**CITY OF PORTLAND, MAINE**  
**HISTORIC PRESERVATION BOARD**

April 29, 2013

Re: Exterior Alterations; 46 Avon Street

46 AVON  
REAR VIEW

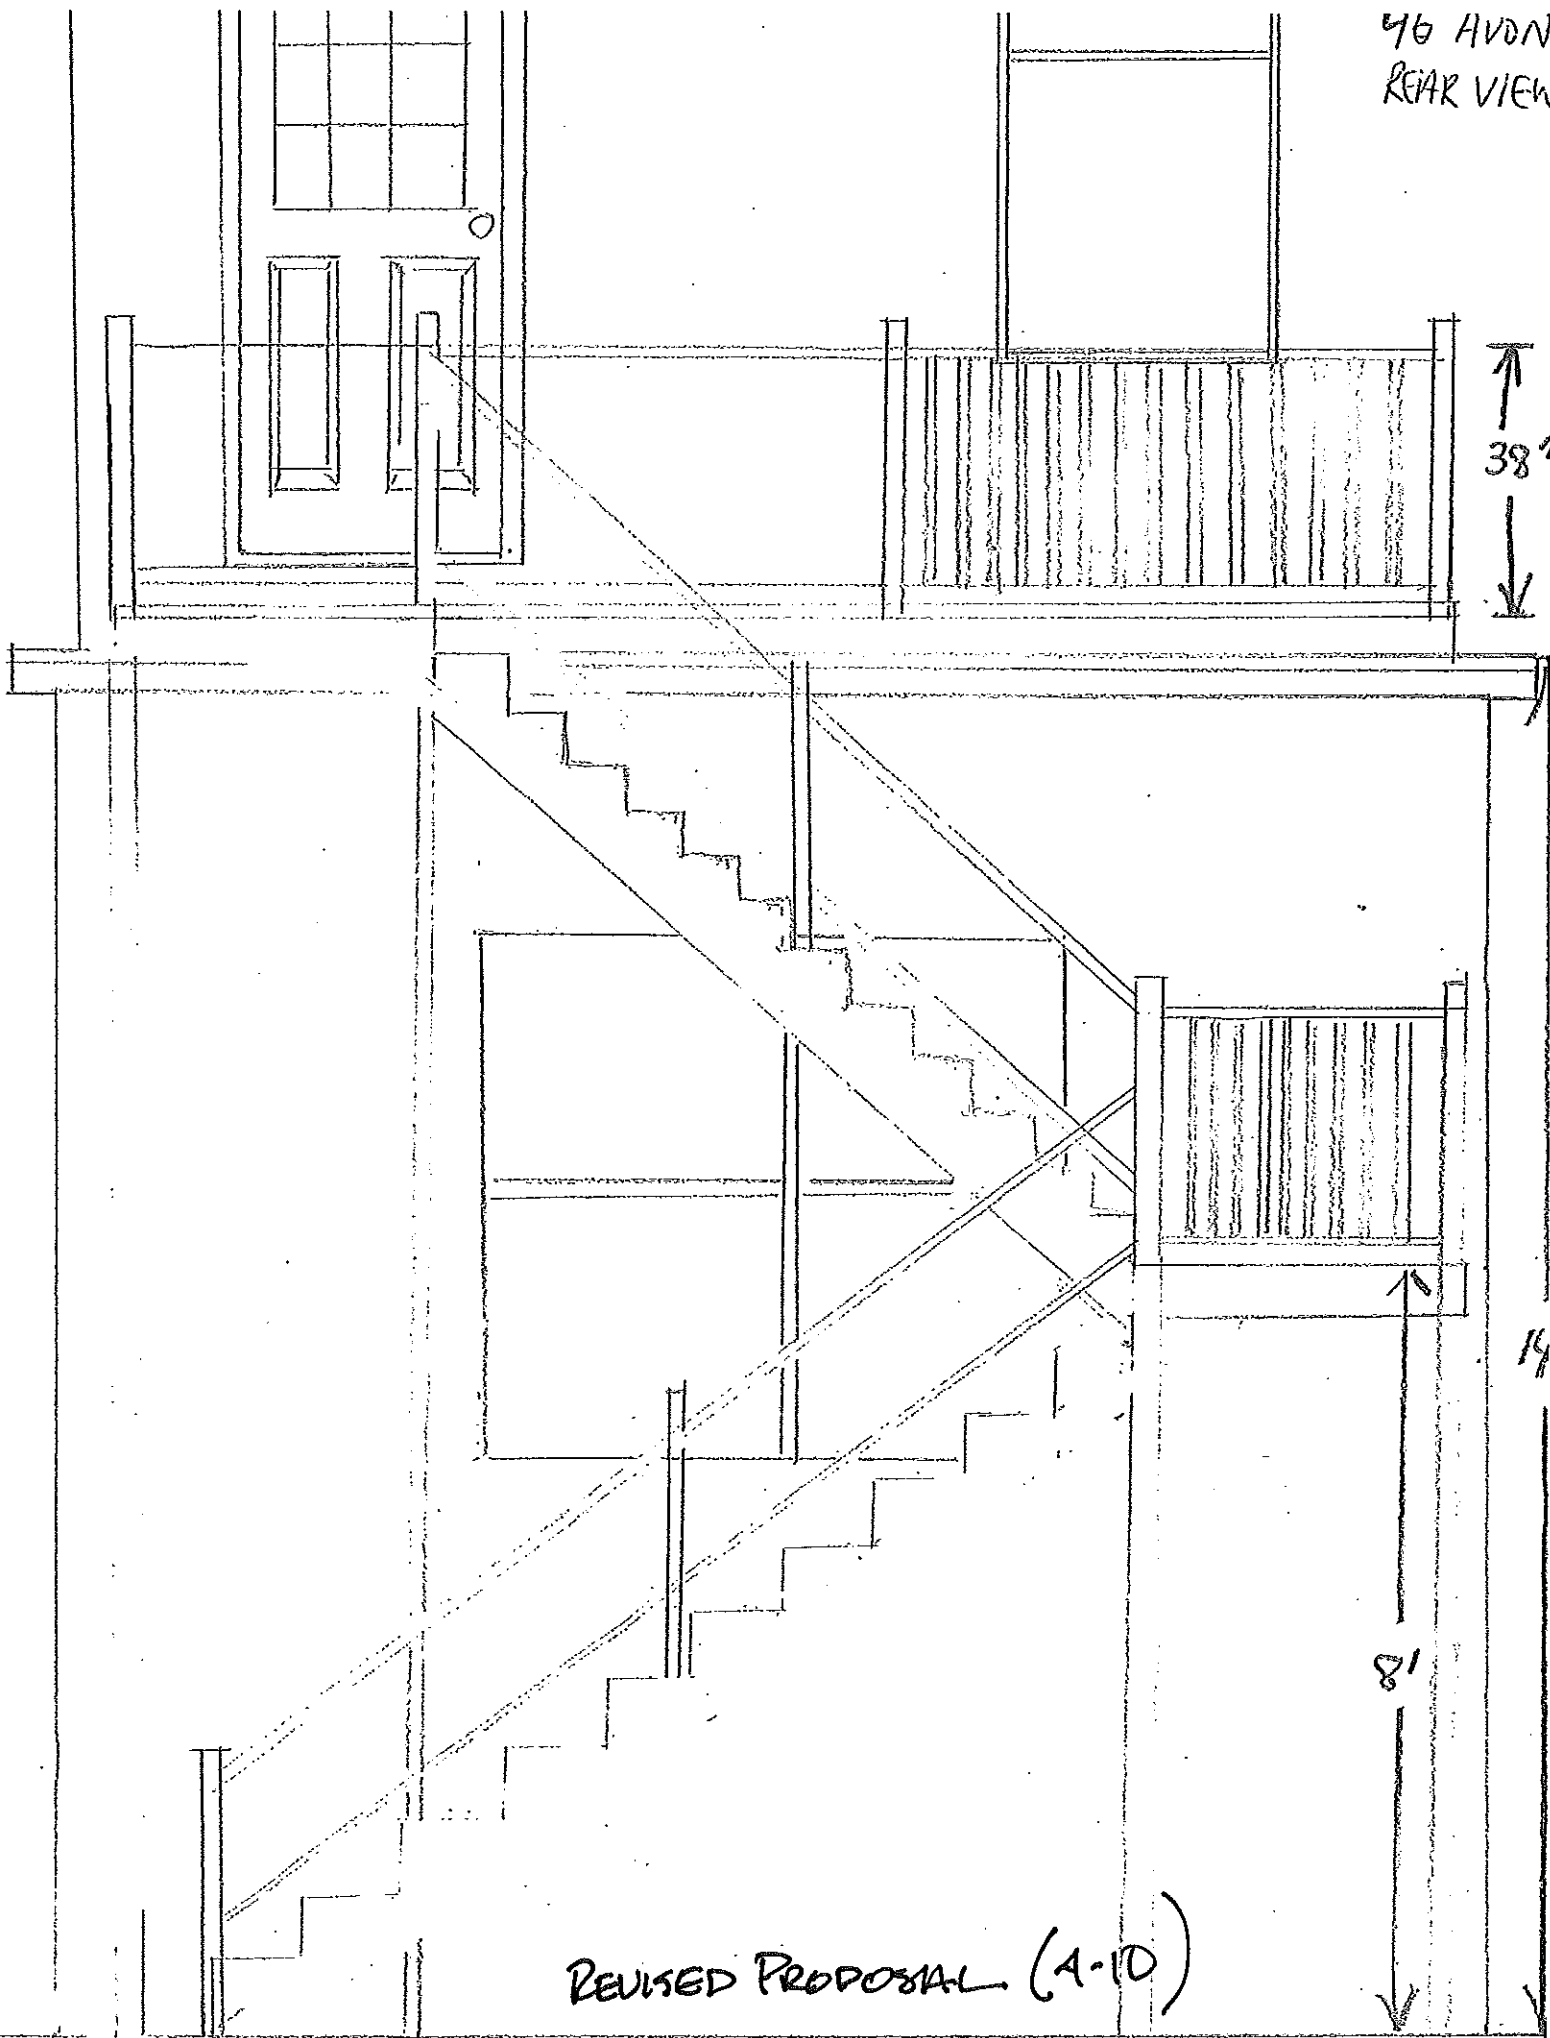
1. Applicant to inform Historic Preservation staff when painting is completed, including pressure-treated stair carriage, risers, and landing framing.
2. Railing system of white vinyl is to include post sleeves and "New England" post caps.
3. Pressure-treated posts supporting landings and stairs shall be wrapped with white painted trim stock.
4. Historic Preservation Board recommends the granting of historic waivers to lower guardrail heights if possible.
